# PUDSP19005-R3-LOI-Redlines Summary\_Markup Summary

# PUDSP19005-R3-PUDSP-Redlines Summary\_Markup Summary

TRACT DETAILS
P2 OF 11

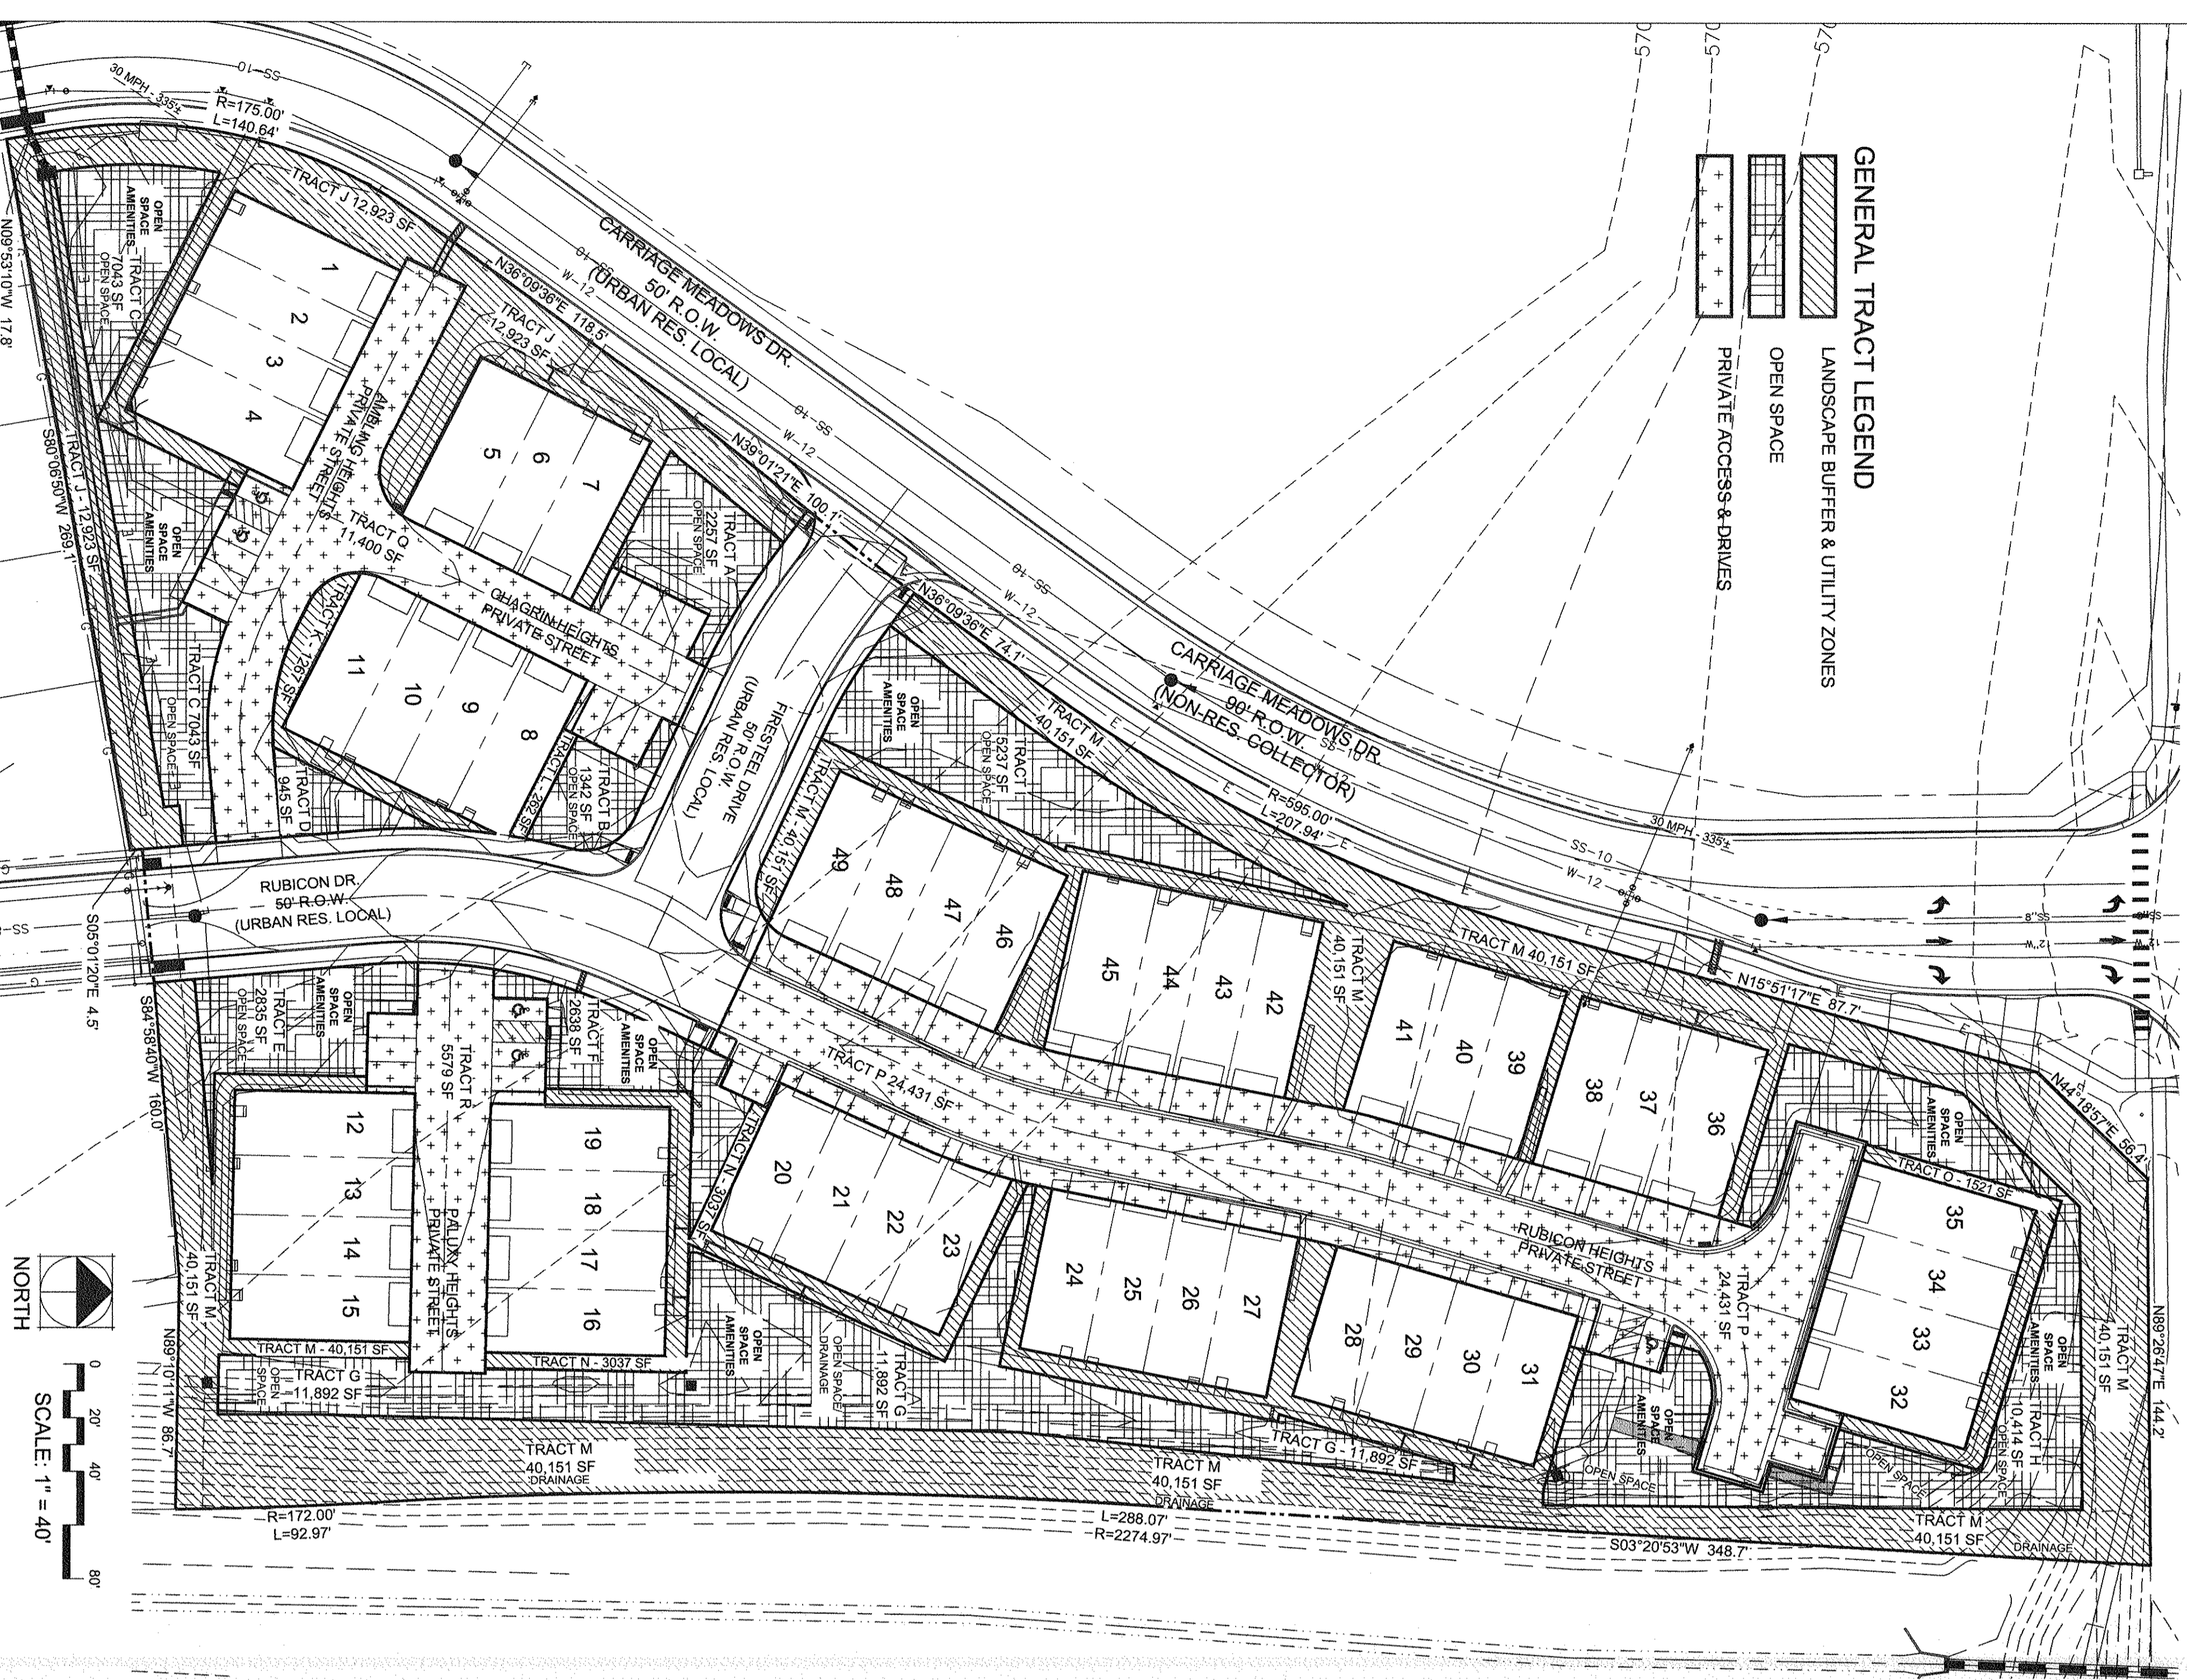
sidewalk (pedestrian easements along the private rods that cross over lots)

Since you have this here remove from accessory uses- these uses are the principle allowed uses in the tracts...

play ground equipment, gazebos

Hatching is great to clarify...can you provide a key of what the hatching is depicting?

Driveways & Parking

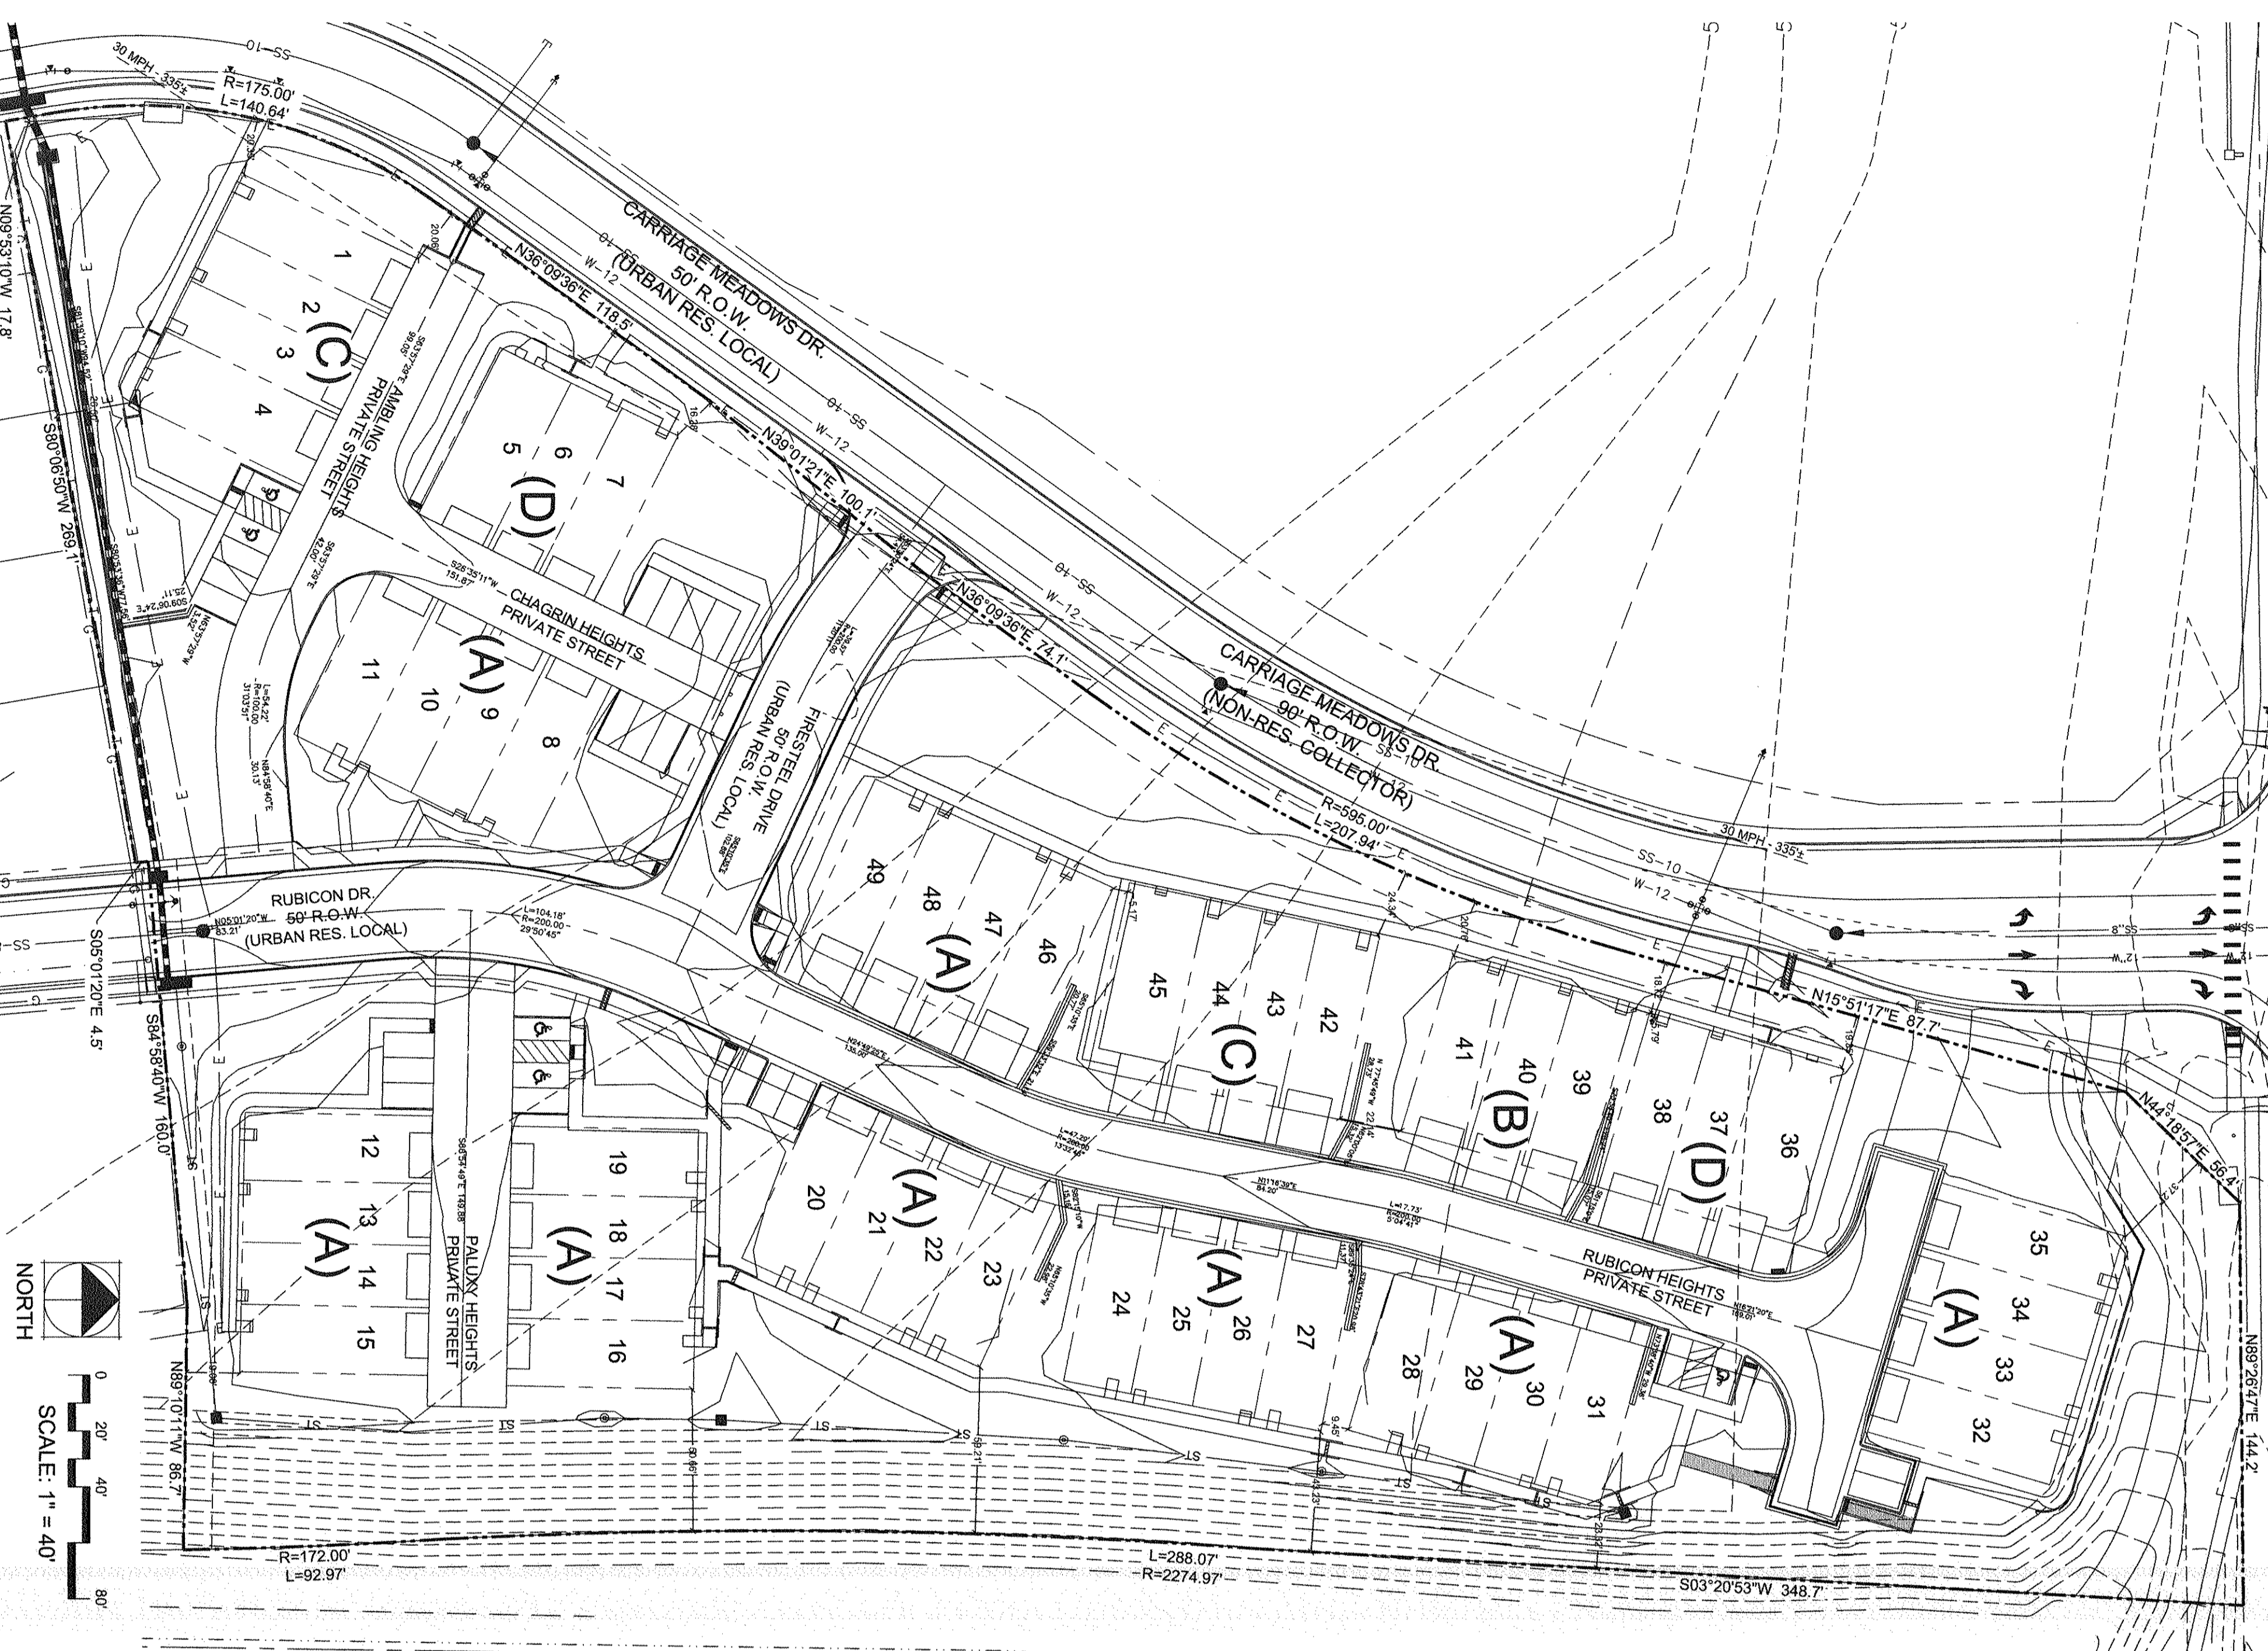
so if a driveway is 20-foot one can store their rv vehicle or boat?

dont repeat note on first page

TYPICAL STREET CROSS-SECTIONS

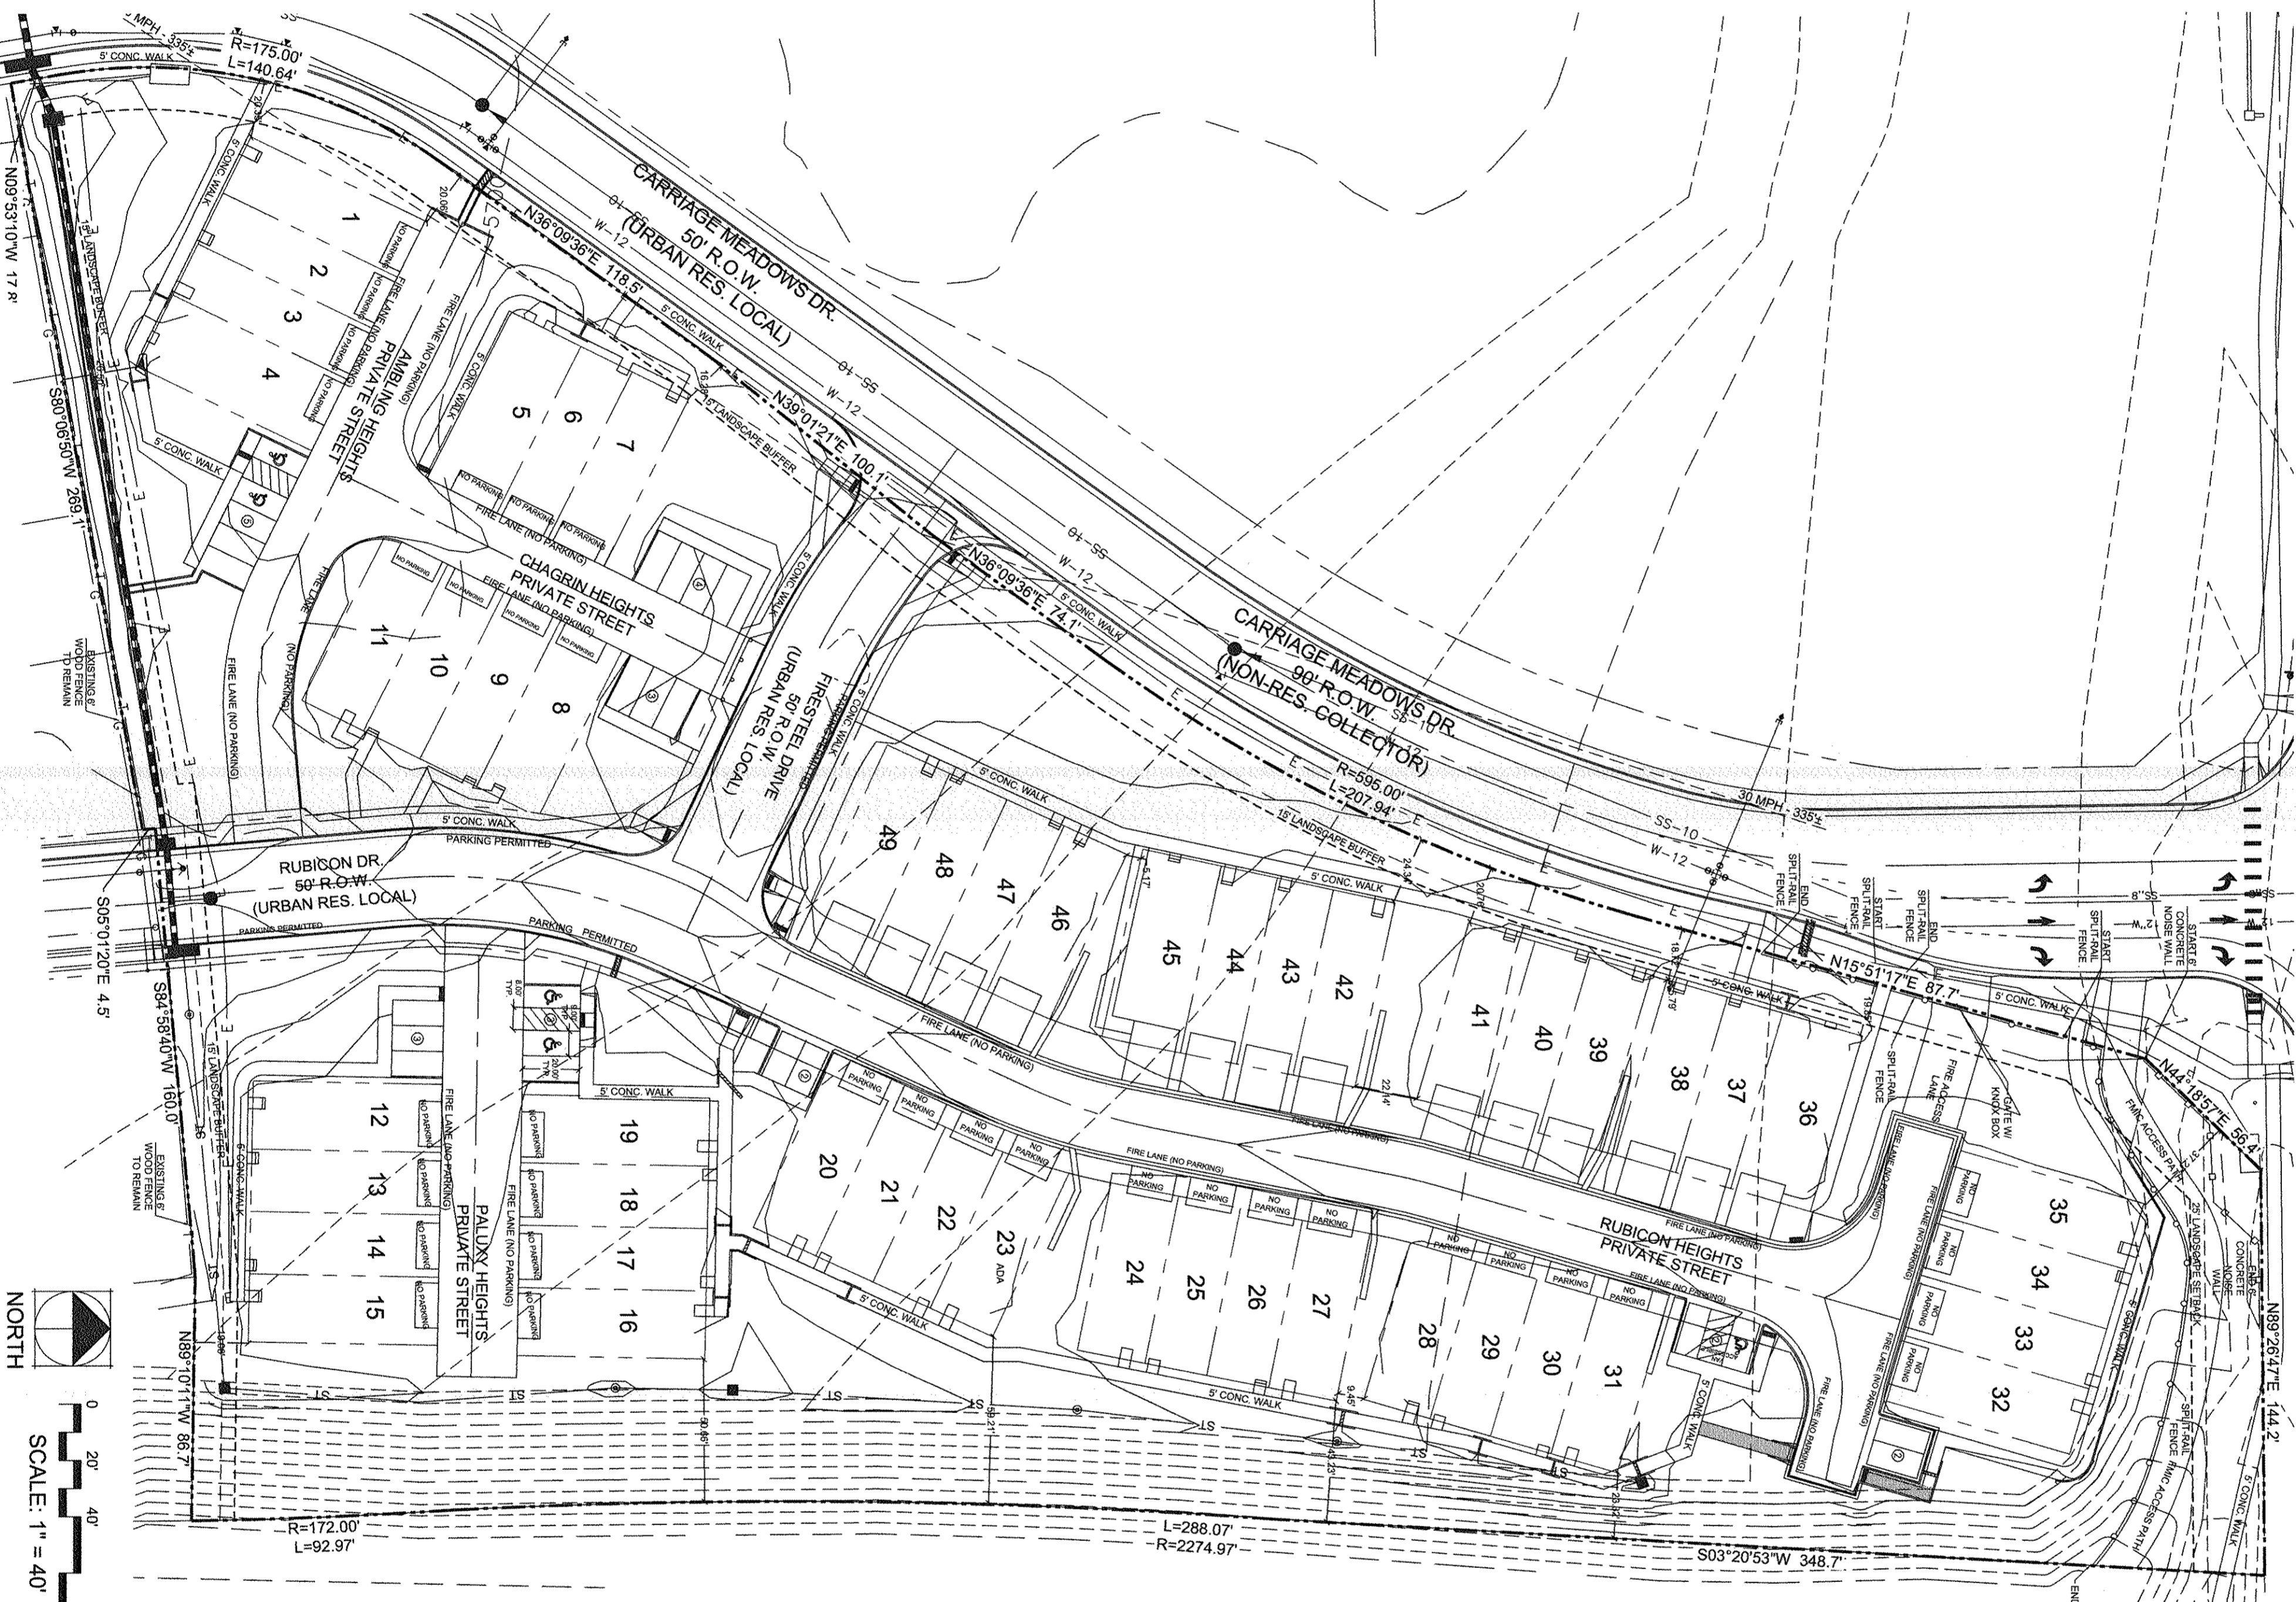
distance- label all widths on all streets sheets 2-6

this sheet?

Provide all preliminary plan checklist items.
